**Notice of Exhibition  
Ivanhoe Estate Redevelopment – Concept development application (SSD 8707)**

Thank you for your letter dated 9 April 2018 requesting Transport for NSW (TfNSW) comment on the subject State Significant Development (SSD) application for the redevelopment of the Ivanhoe Estate, Macquarie Park by the Aspire Consortium on behalf of Land and Housing Corporation (the Applicant).

## **Attachment A – Detailed Comments on SSD 8707**

TYPICAL ROAD SECTION - ROAD No.1 (WITH PARKING BAYS)
SCALE 1 : 100

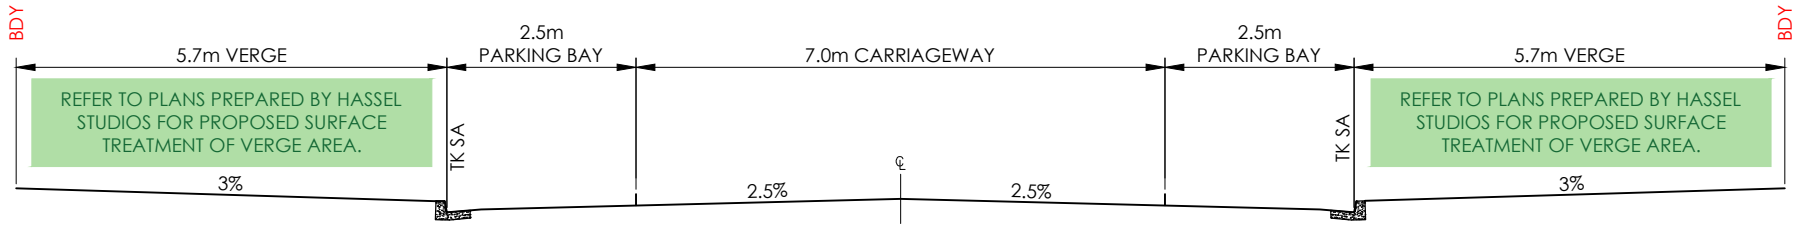
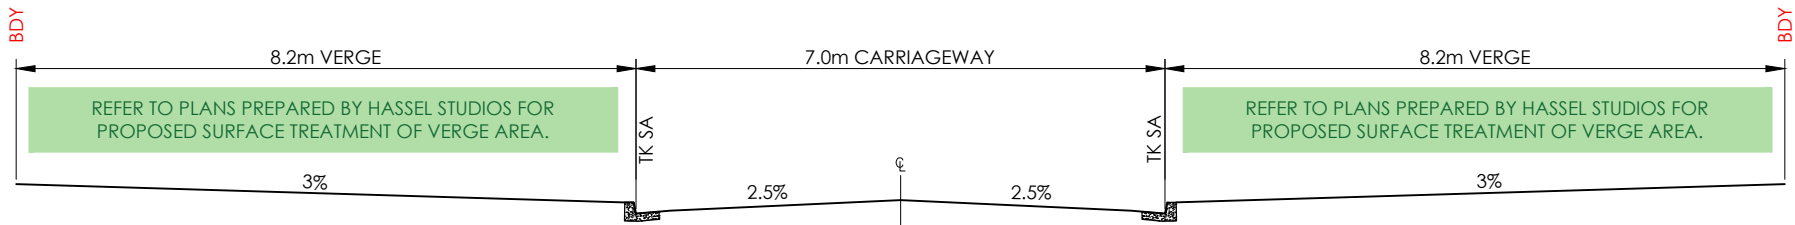
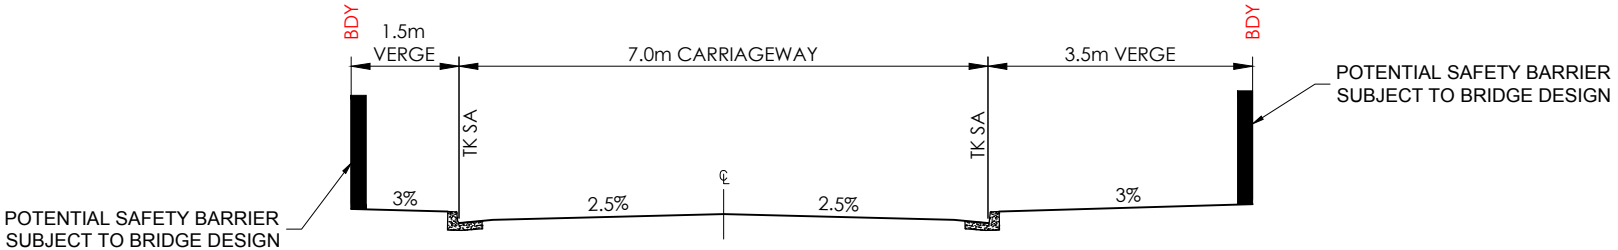
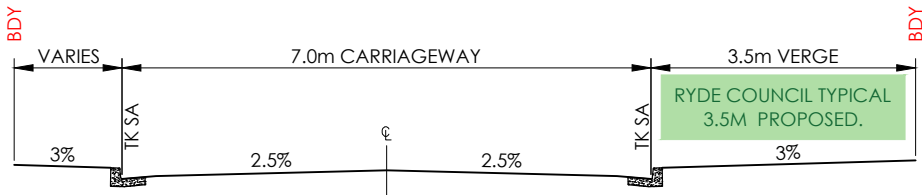
- Main Street should be bus capable to ensure options are available for future bus service planning, should be designed with minimum 3.5m travel lanes and be able to accommodate 14.5m buses. Any kerbside lanes/indented bays for bus stops should be 3.0m in width.

The proposed Main Street will form one of the few internal precinct links between Herring Road and the southeastern portions of Macquarie Park. It will provide access to the proposed high school, which is expected to utilise bus services for various school activities and transport options. Furthermore, future public bus services may utilise this road, if required.

As such, Main Street should be bus capable (standard 14.5m buses) to ensure options are available for future bus service planning.

Main Street should be designed with minimum 3.5m travel lanes and be able to accommodate 14.5m buses. Any kerbside lanes/indented bays for bus stops should be 3.0m in width.
